Rezoning Transportation Analysis

Petition Number: 2022-198

Reviewer: Patrick Monroe
Patrick.Monroe@charlottenc.gov
704-301-1411

Date	Description
4-27-23	First Review (PDM)

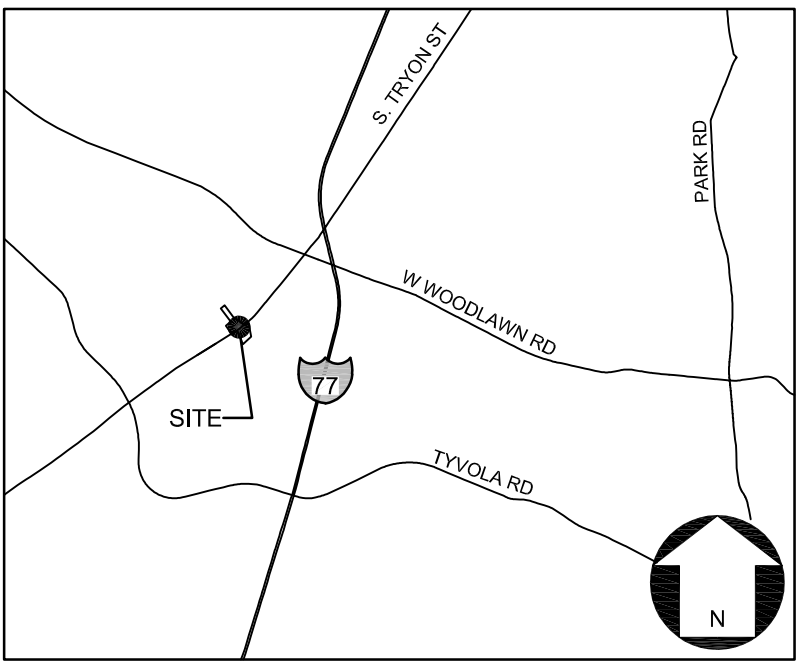
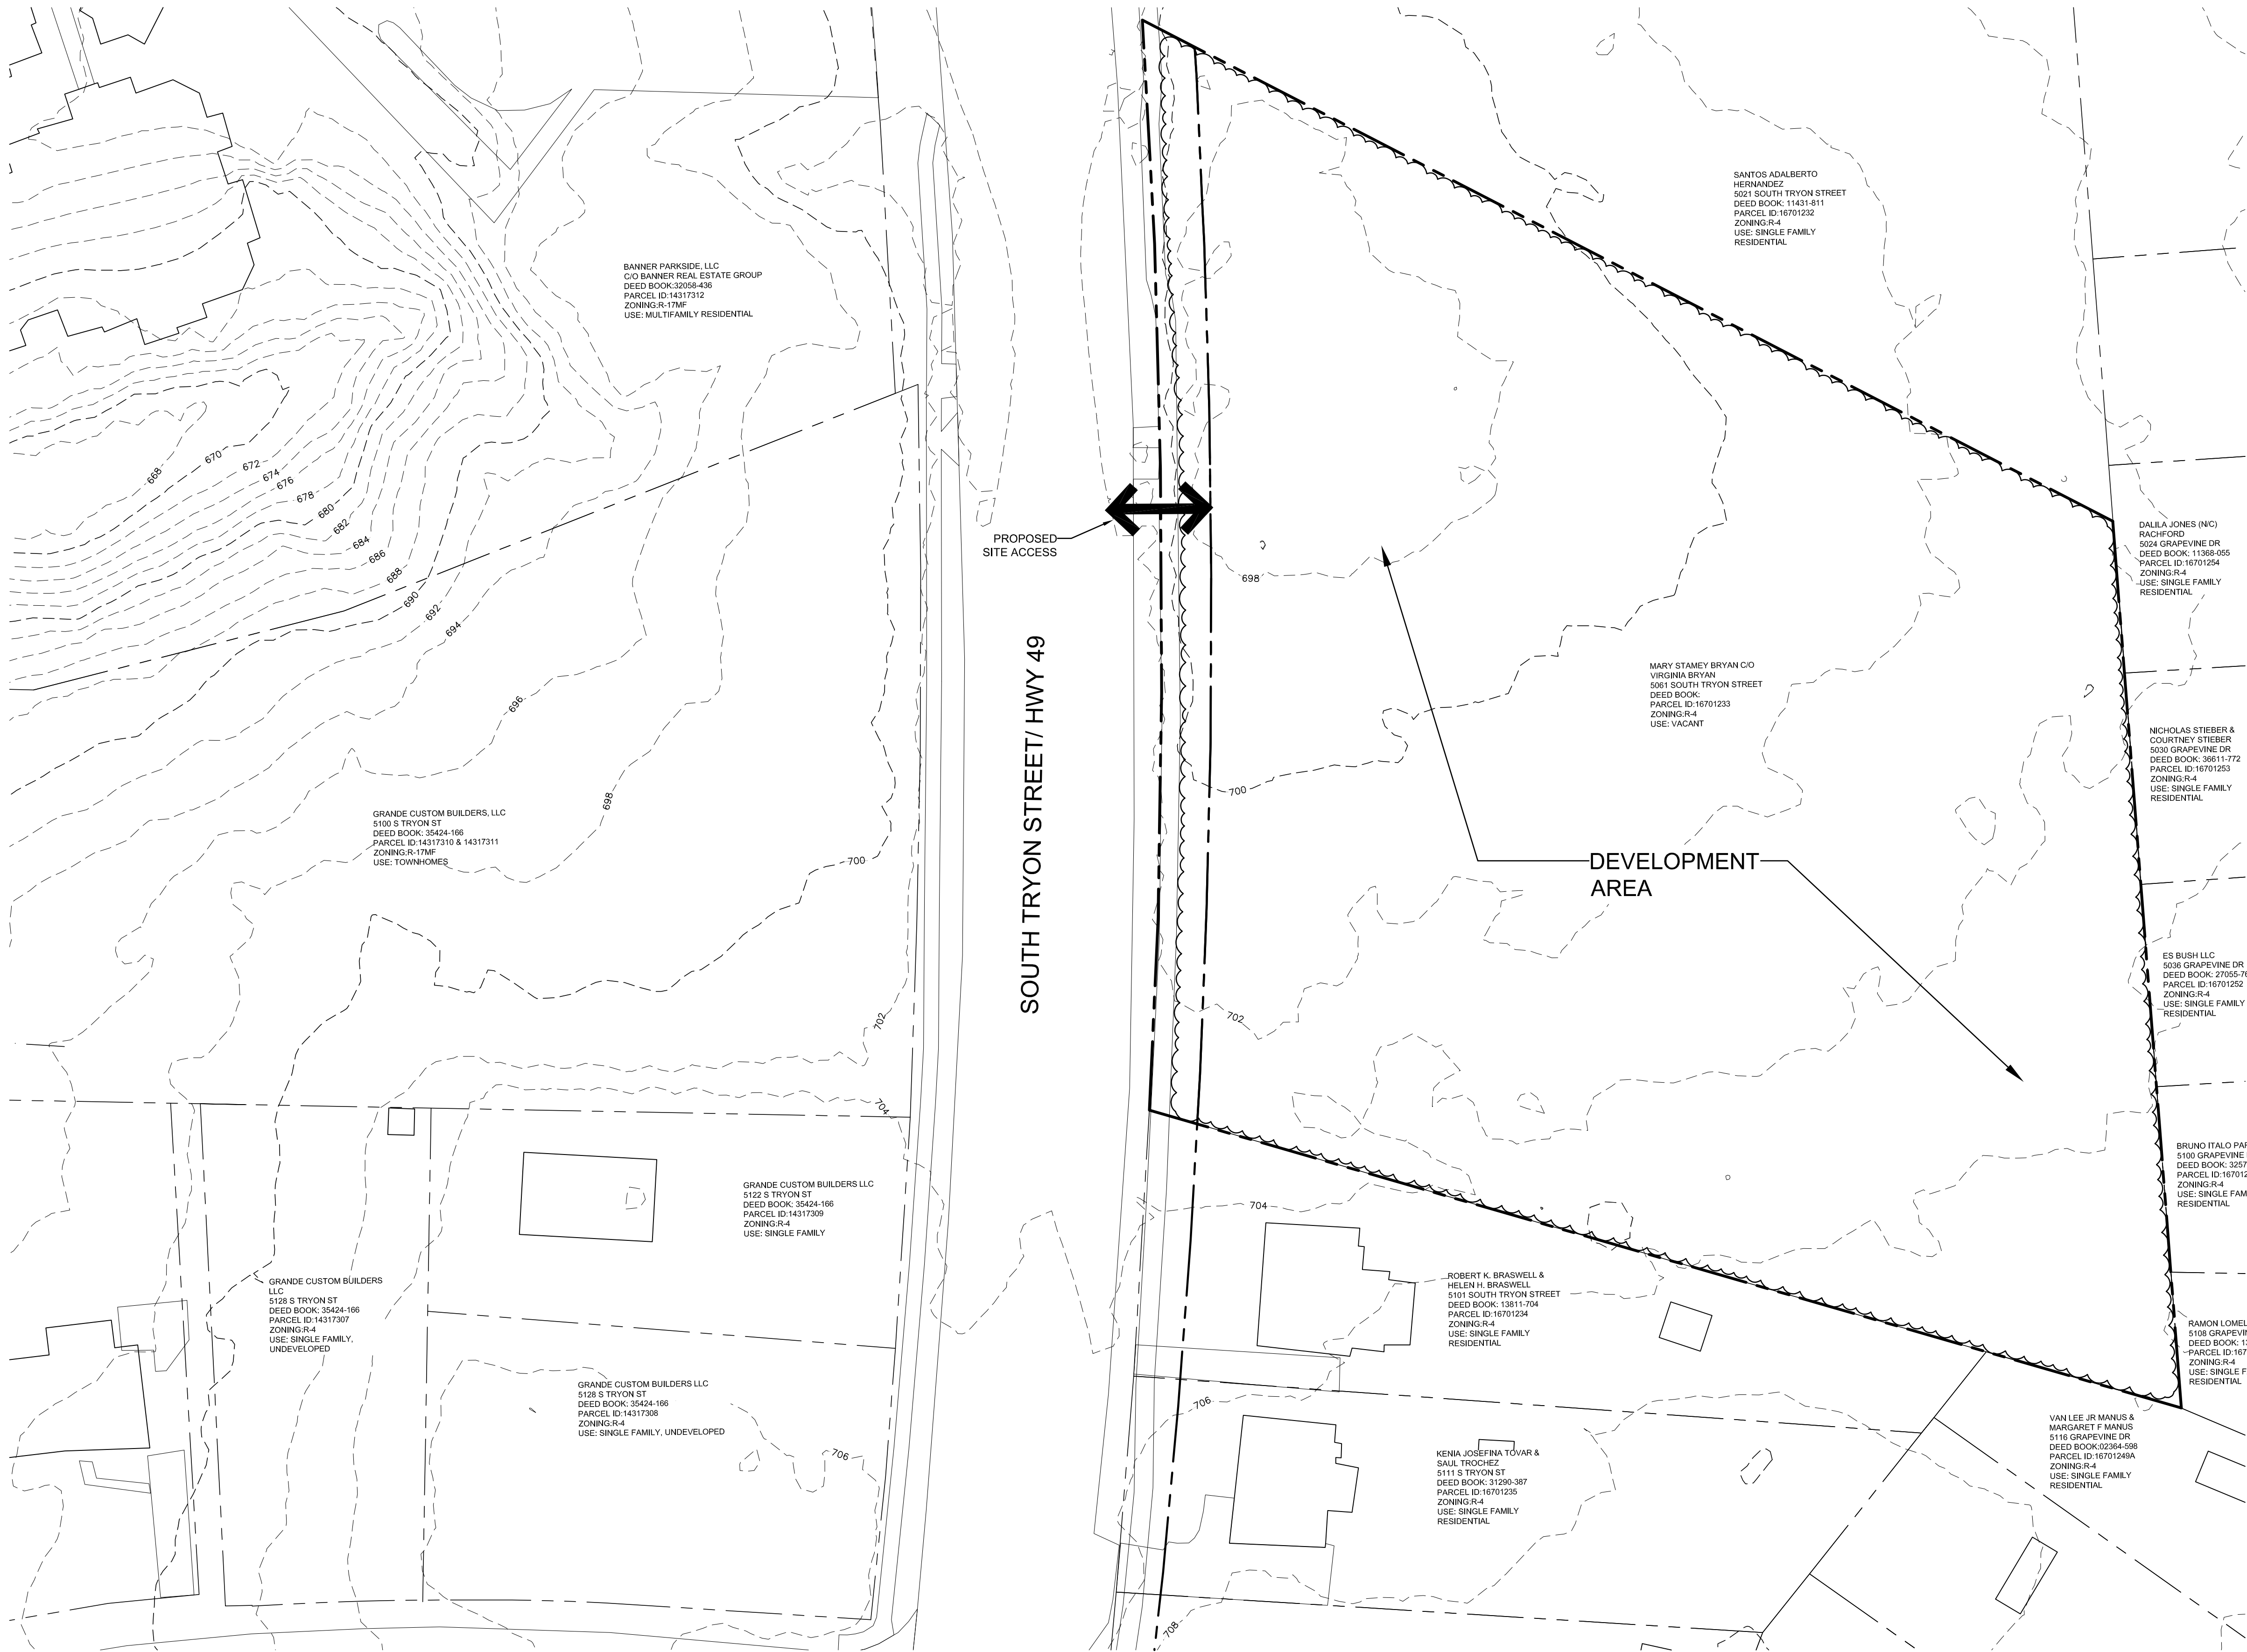
1. Curblines:

South Tryon Street: Future location of curb and gutter to be located 41 feet from roadway centerline to accommodate the Charlotte Streets Map with a roadway typical section of a 6+ Avenue

Label and dimension the curb and gutter from the centerline for each road on the site plan.

3. Revise site plan and conditional note(s) to commit to construct bicycle facilities by locating installing a 12' multi-use path to meet the Council-adopted Charlotte BIKES Policy. Multi-use paths maintained by the City shall meet ADA/PROWAG requirements.

5. Revise site plan and conditional note(s) to show the existing pedestrian refuge/crosswalks and the bus stop.
6. Revise site plan and conditional note(s) to label the street classifications of all internal streets and whether they are public or private.

7. Revise site plan and conditional note(s) to identify the proposed site access as right-in / right-out.
8. Add a conditional note specifying “the Petitioner shall dedicate and convey in fee simple all rights-of-way to the City before the site’s first building certificate of occupancy is issued. CDOT requests rights-of-way set at 2’ behind back of sidewalk where feasible.”
